**Natural England's Written Representations in respect of Dean Moor Solar Farm
- EN010155**

Examining Authority's submission deadline **26 August 2025**

Natural England's advice in these written representations is based on information submitted by FVS Dean Moor Limited in support of its application for a Development Consent Order ('DCO') in relation to Dean Moor Solar Farm (*the project*).

Environmental Statement: Chapter 3 – Figure 3.5 Exclusion Areas

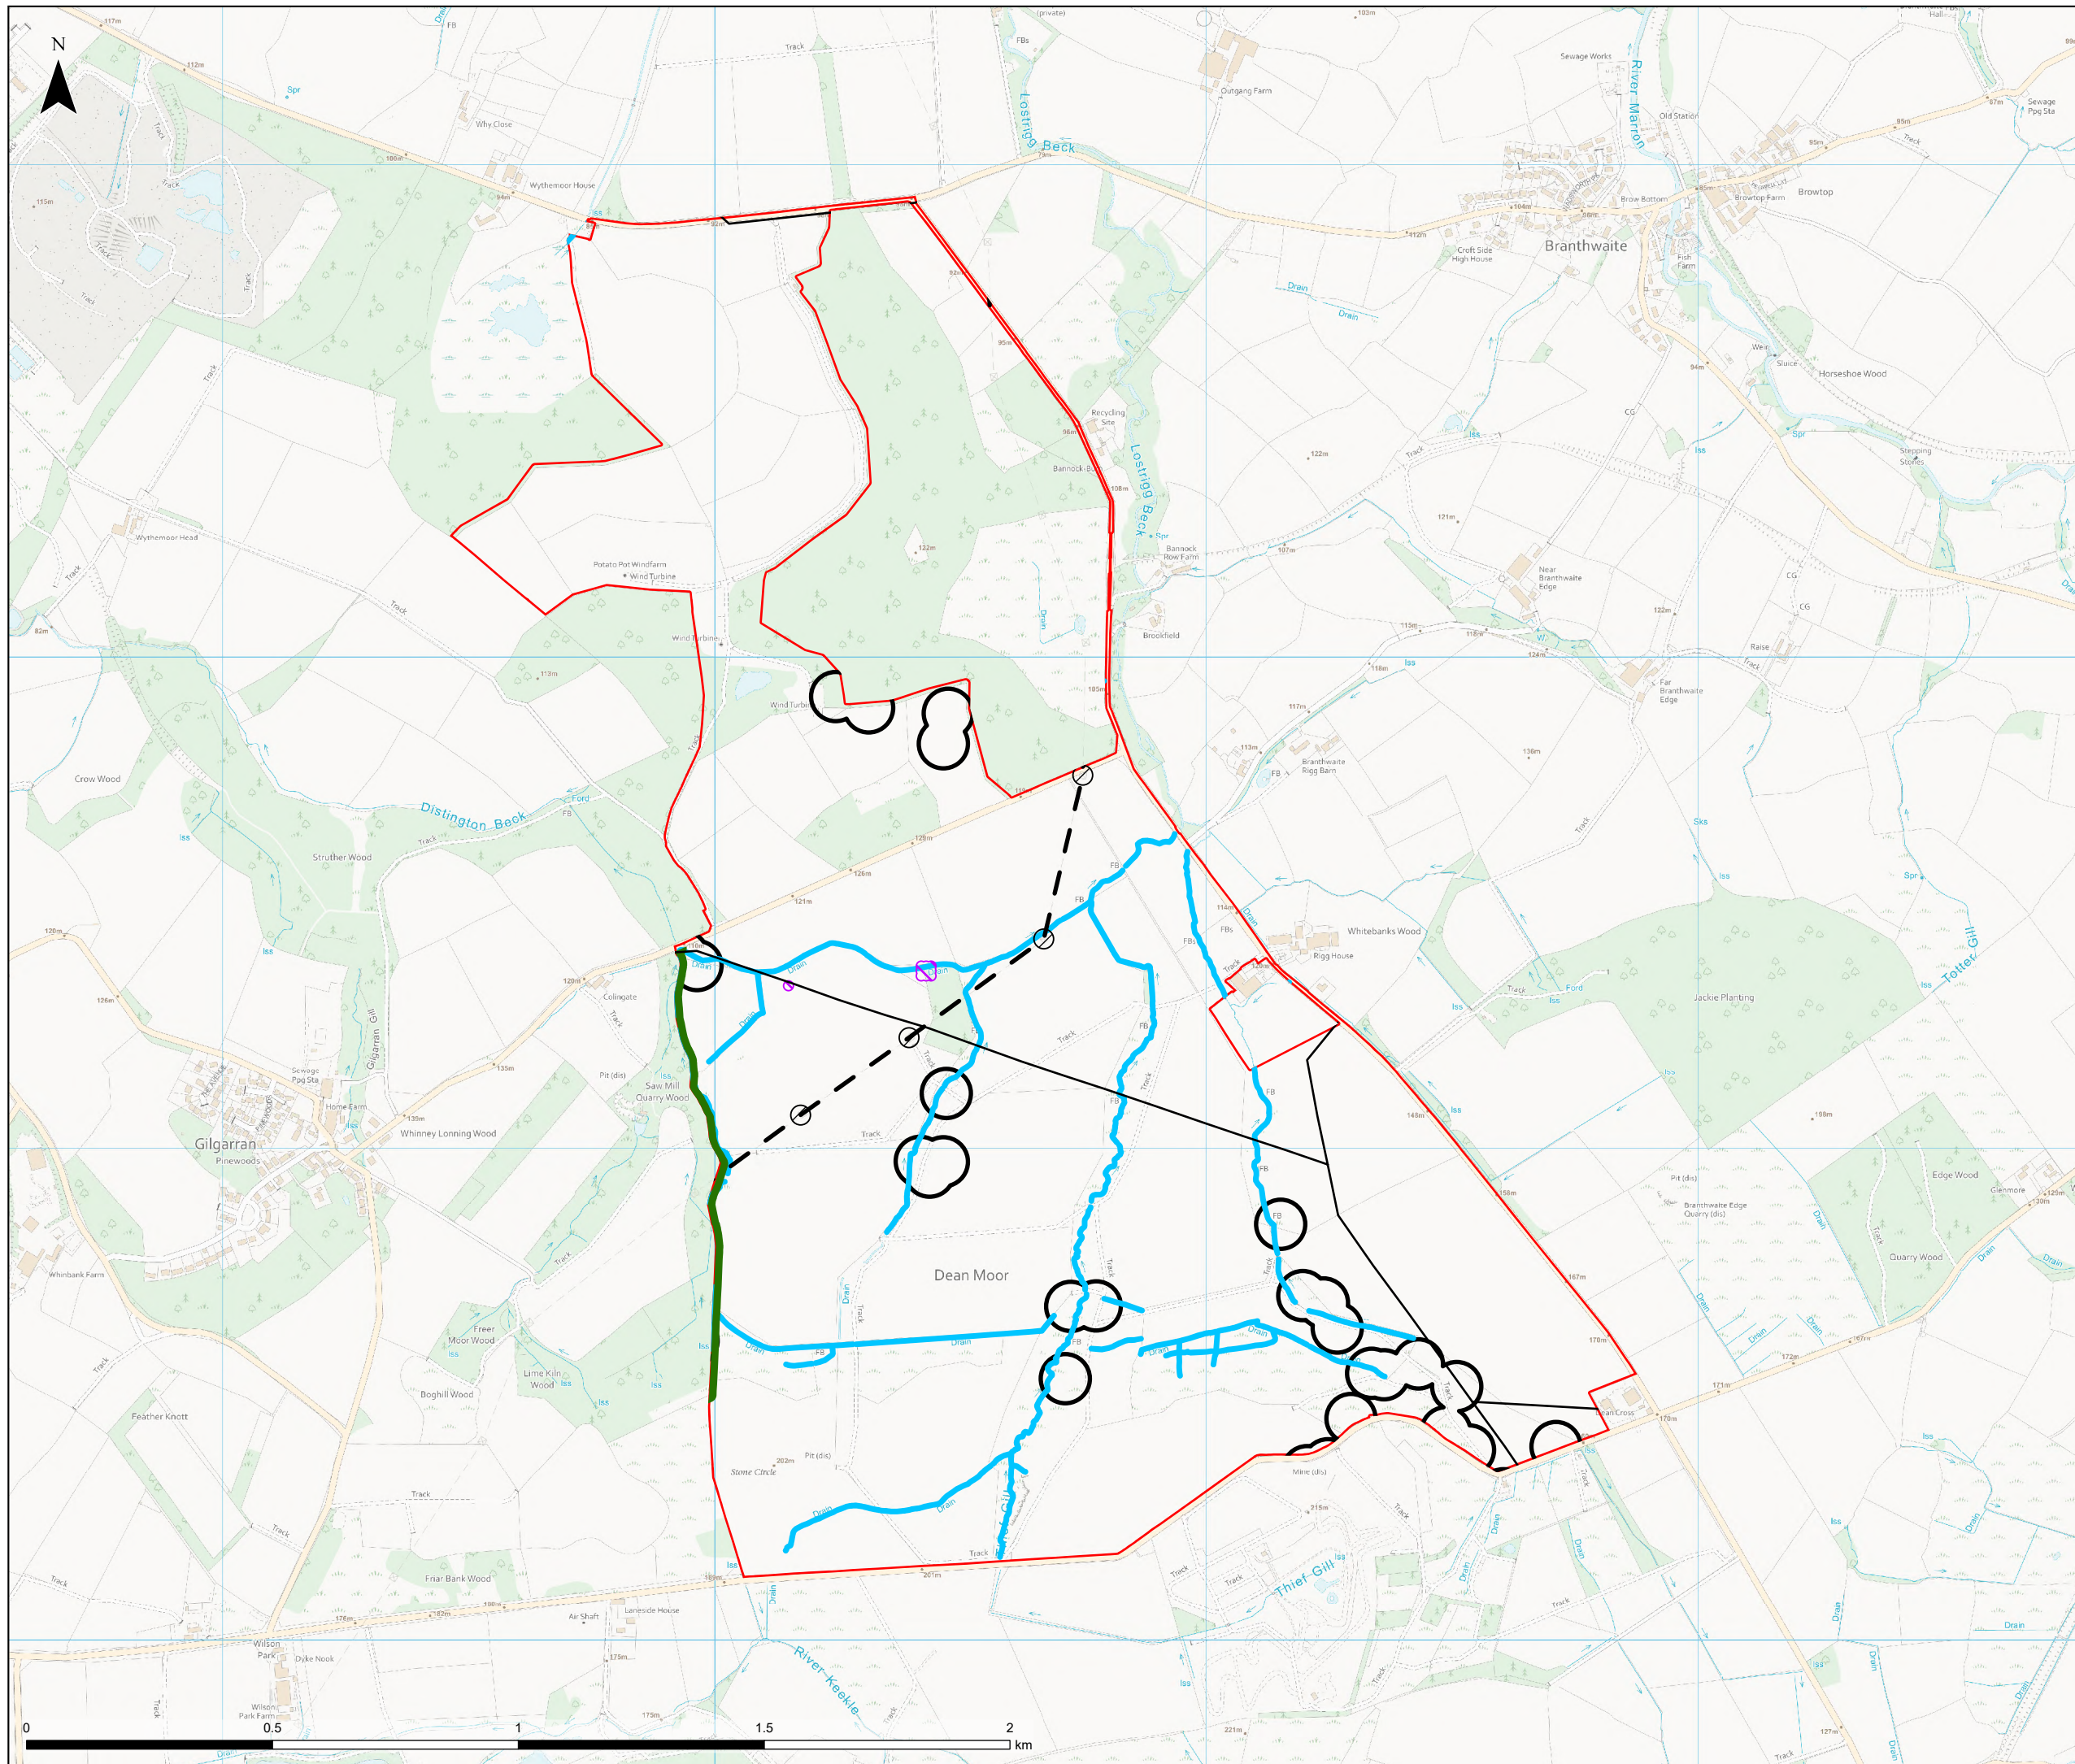
Natural England advise that once the above points have been considered that a plan is provided to indicate the areas of the site where peat depth of 40cm and above is located. This will then determine suitable exclusion areas. Currently Figure 3.5 of the Environmental Statement includes very minimal exclusion areas for peat.
